Table of Amendments to the Development Consent Order (DCO)

Wheelabrator Kemsley (K3 Generating Station) and Wheelabrator Kemsley North (WKN) Waste to Energy facility Development Consent Order

PINS Ref: EN010083

Document 2.7
March 2020 - Deadline 2

Status	Drawn By	PM/Checked By
DEADLINE 2 VERSION	CR	TS
Job Ref		Date Created
OXF9812		MARCH 2020
Document Reference		Document Number
9812-0031-10		5.6

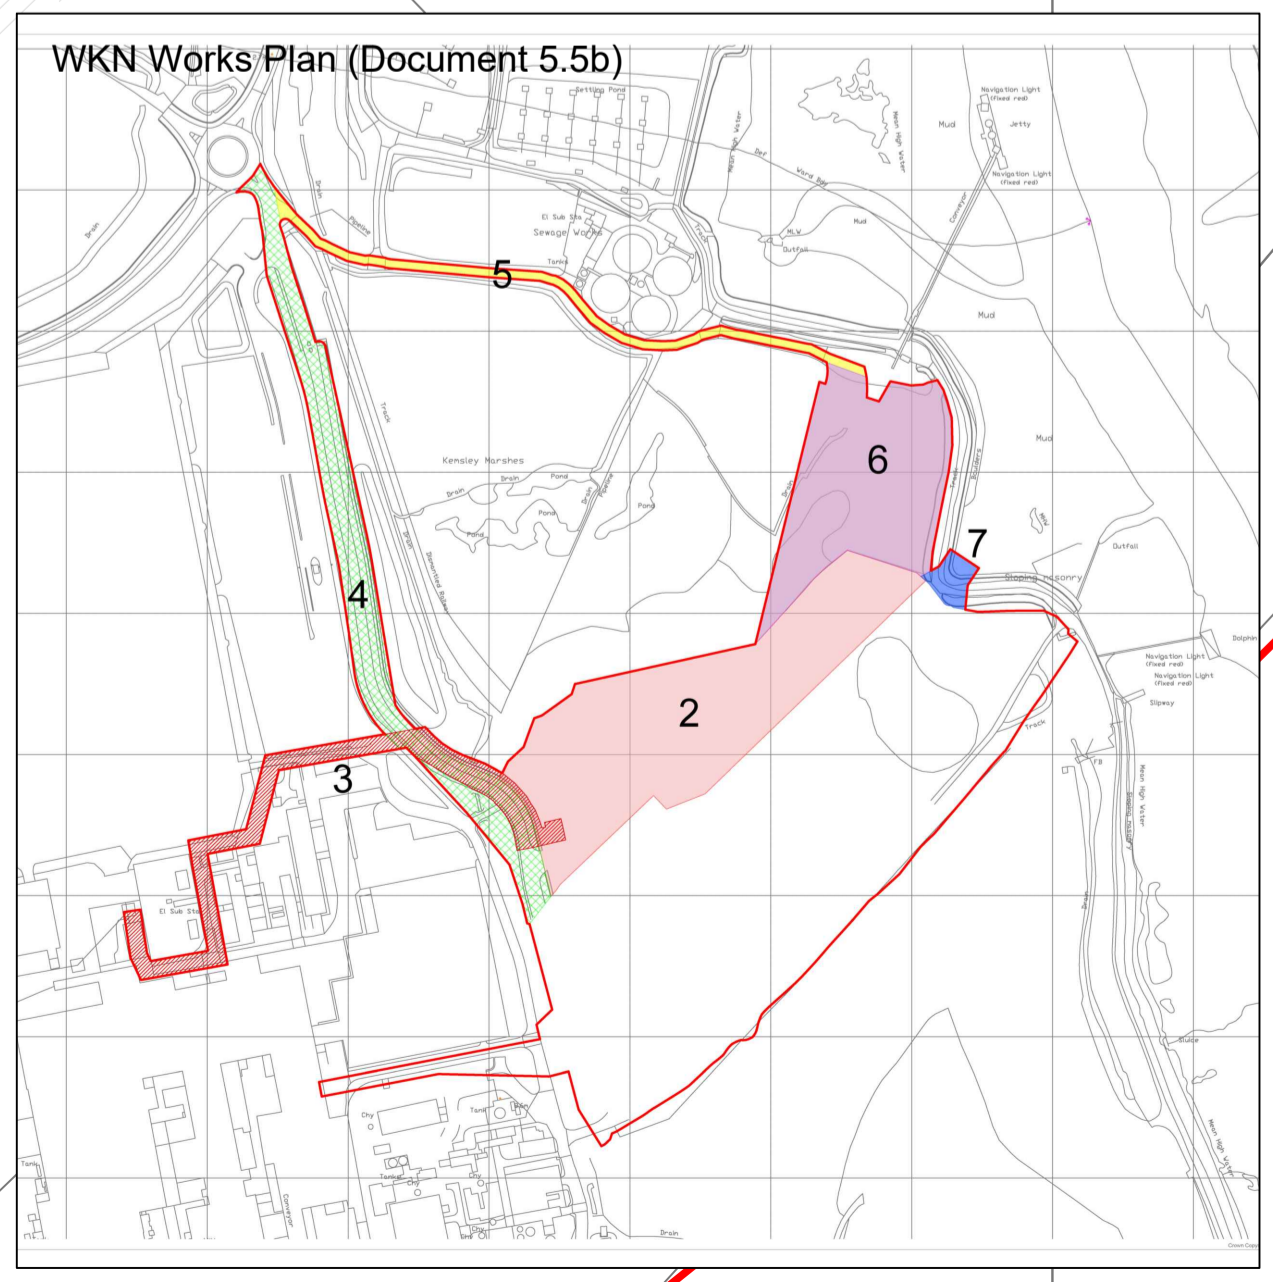
Part of DCO	Change	Reason
Article 13(2) and (3) Defence to proceedings in respect of statutory nuisance	The references to section 65 Control of Pollution Act 1974 have been deleted.	Amended in response to the ExA's question ISH10.
Article 16(g) Certification of plans etc	The reference of the WKN parameter plan has been moved from 16(c) to 16(g).	For consistency with the definition in requirement 1 and in response to the ExA's first written questions 1.2.2. Further information is provided in the Applicant's Further Submissions on ISH1 DCO Questions – Deadline 2.
Article 18(1) Procedure for approvals	“The Order” changed to “this Order”.	Amended in response to the ExA's question ISH12.
Schedule 2, Parts 2 & 3 Requirements	Various references to the relevant project or works number have been added throughout to clarify to which work each requirements relates.	Amended in response to the ExA's question ISH18.

Schedule 2 Requirement 14(4) Detailed Design Approval	Duplication of "(4)" deleted. Definition of "WKN parameter plan" moved to requirement 1.	Amended in response to the ExA's question ISH30.
